Big Buck Ridge

Cory & Becky Andrus have elected to move forward with their long plat, Big Buck Ridge. Some of us who neighbor this property, received a Notice of Application this week, a copy is attached. Project: LP-07-00040

PROJECT#	SHEET: 2
2007-389	OF: 3

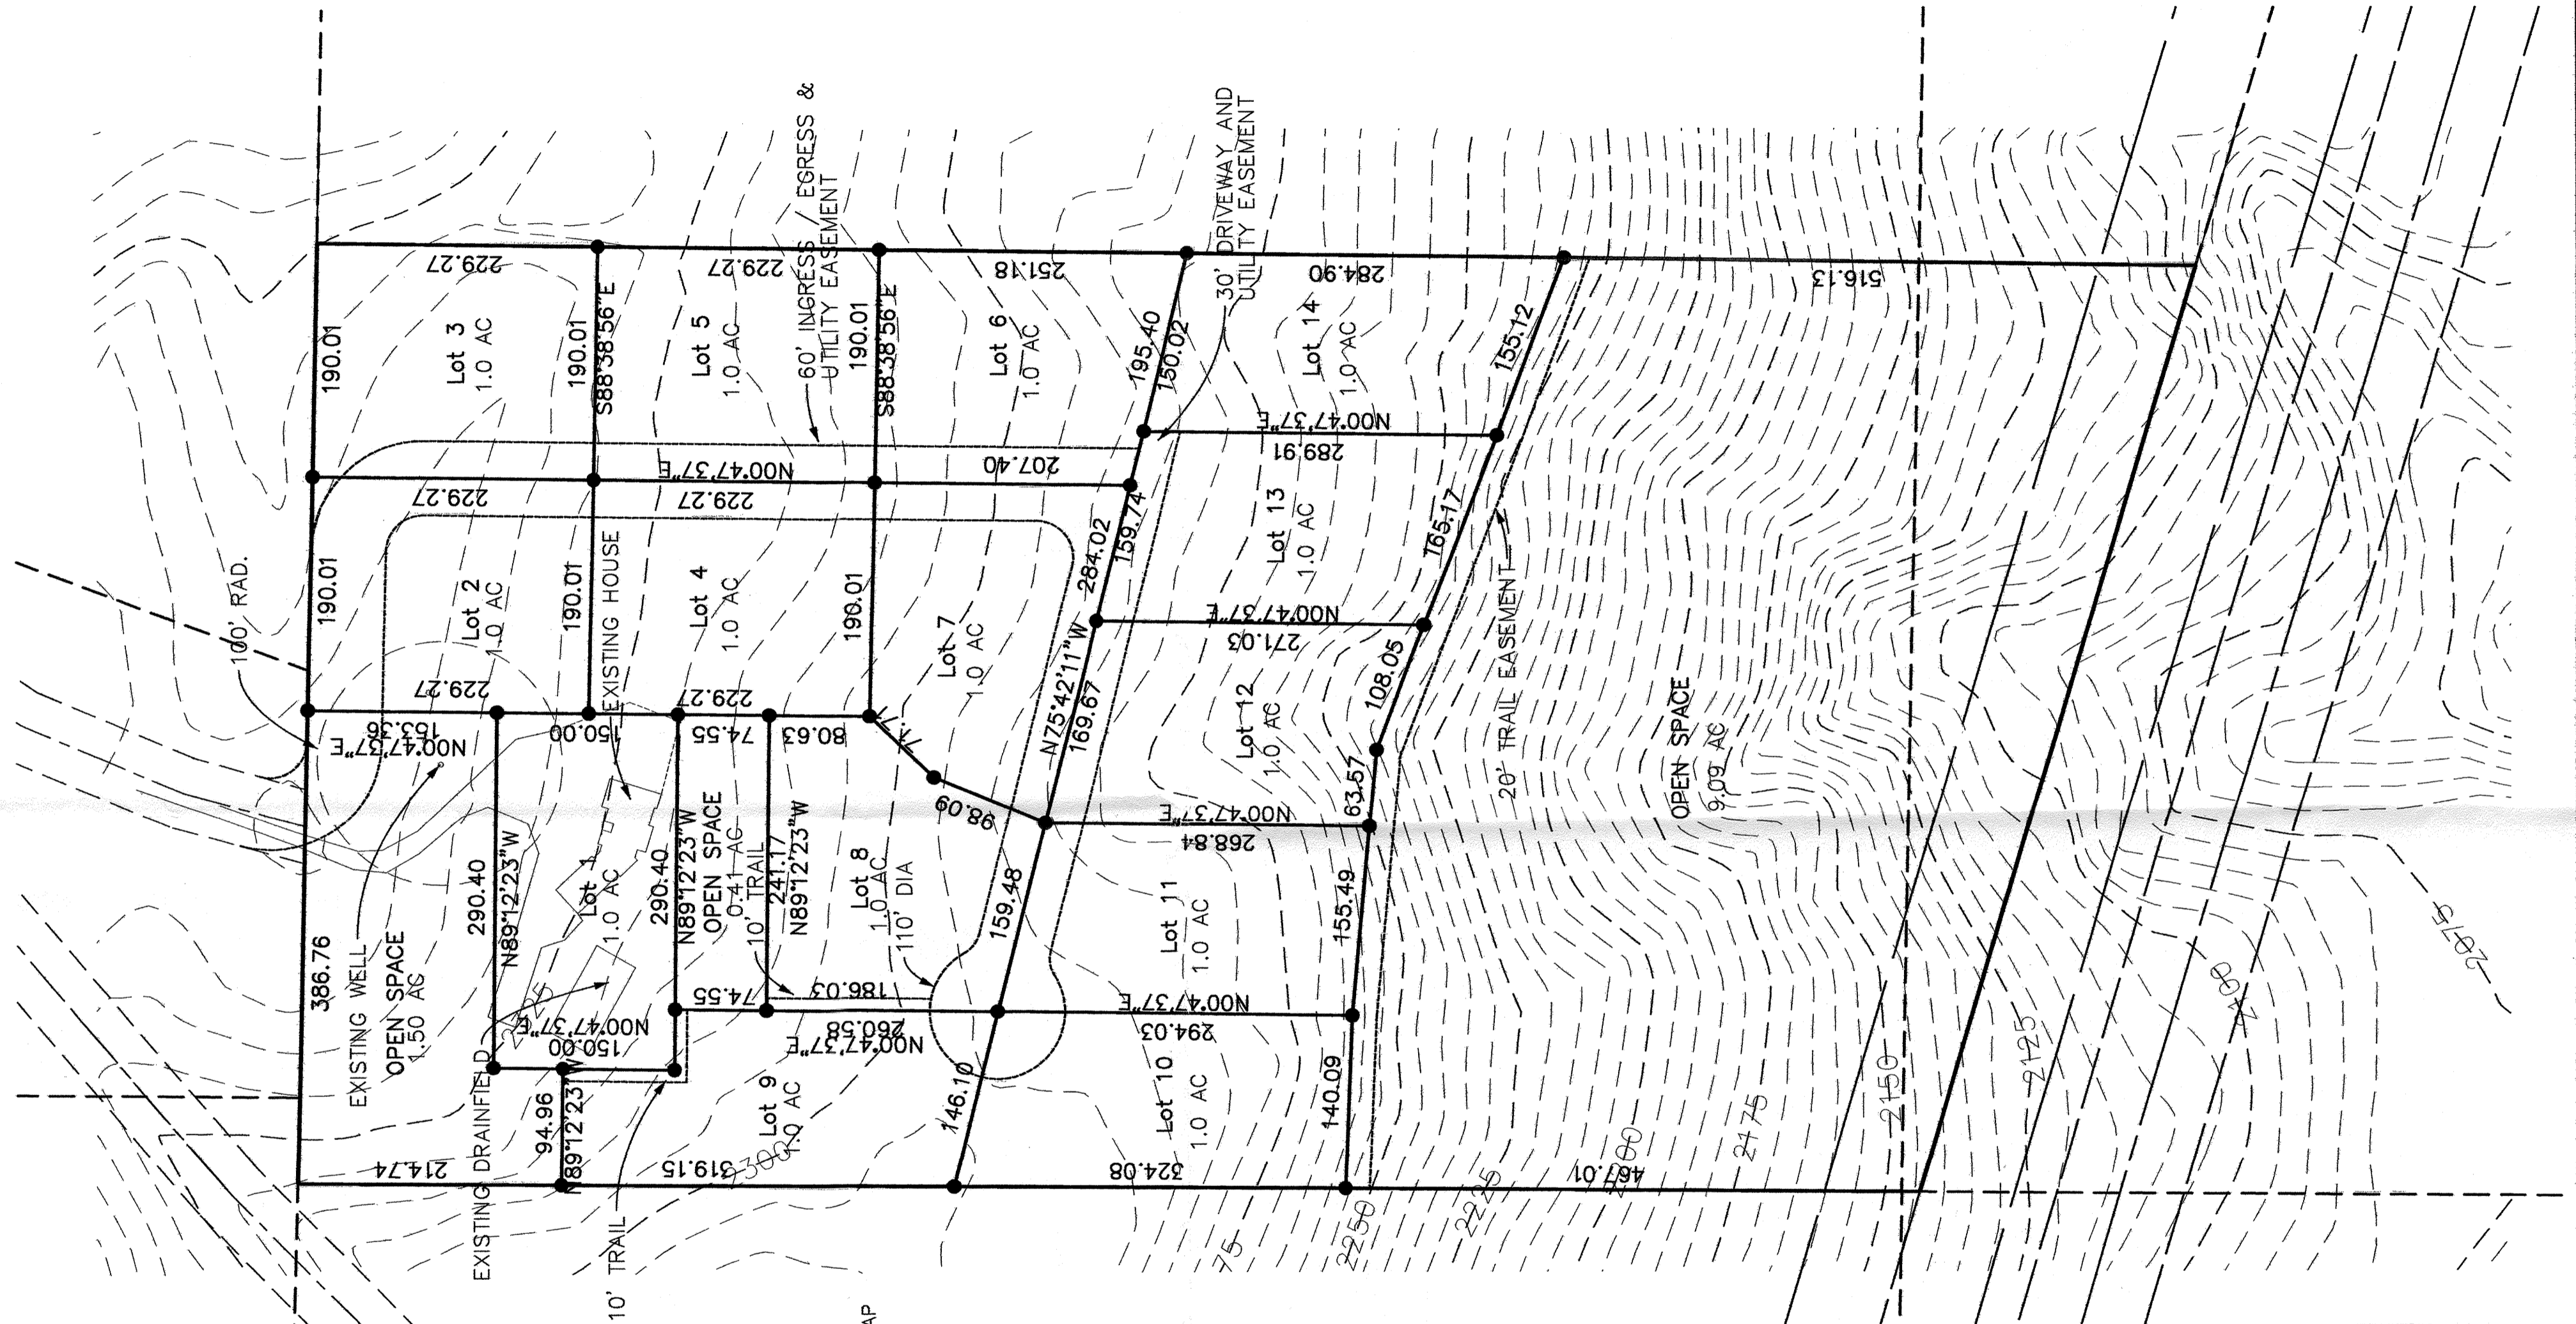
As a side note, the Big Buck Ridge (BBR) plat has a road variance in the submittals. This plat can actually access thru Columbia or 6<sup>th</sup> and not access through Montgomery. The plat entrance is right next to where Columbia/ Sun Ridge pops out. I'm not an expert at these types of items, but in reading the

variance, it assumes that eventually, the easement over Deer Creek will be widened to meet code. It isn't widened right now so the plat should be refused, in my opinion.
